Application ID Number: 2-0116

Department: Fire

Status: Approved with Conditions

Reviewer: Lt. McDougall

Miscellaneous Details

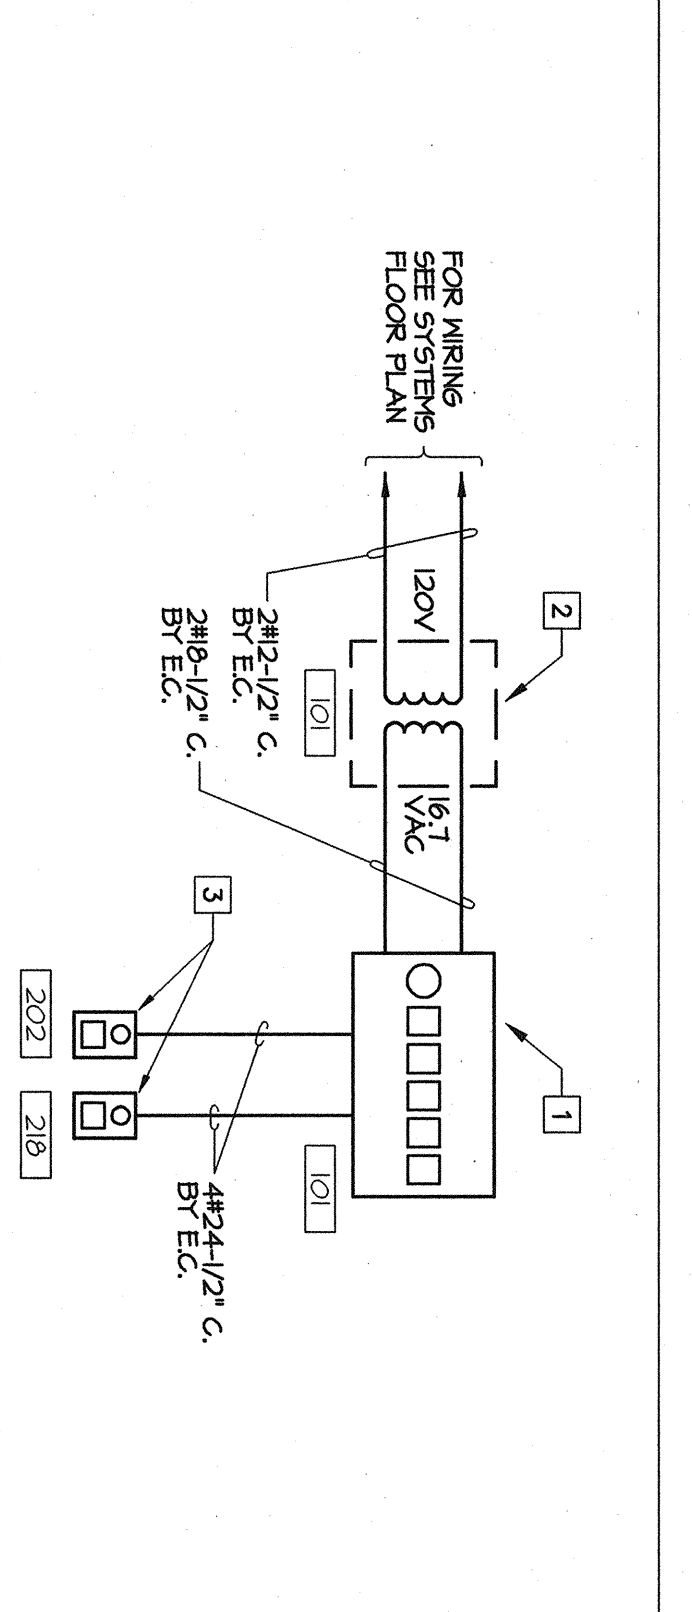
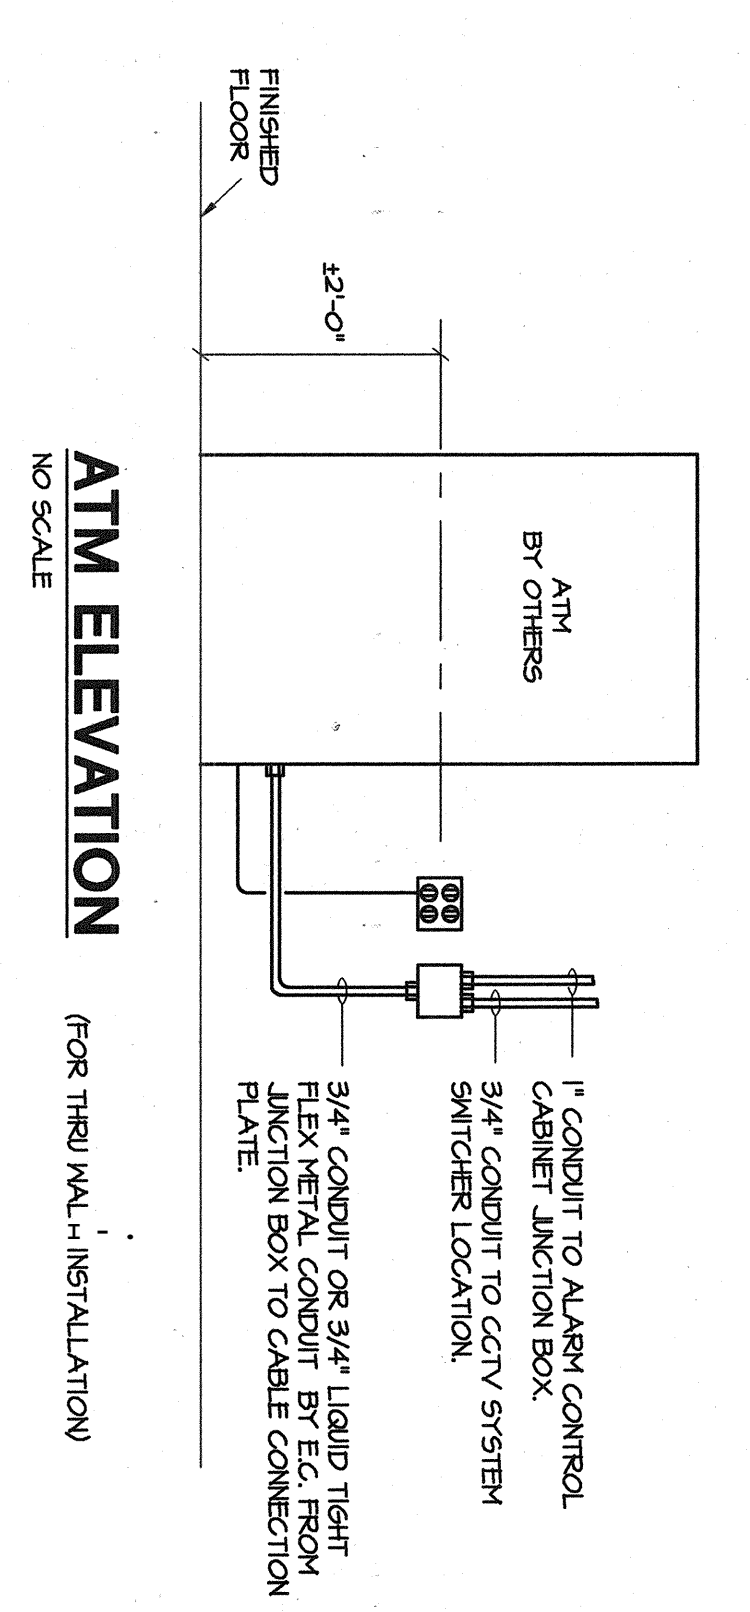
the fire alarm system shall be installed in accordance with NFPA 72 standards
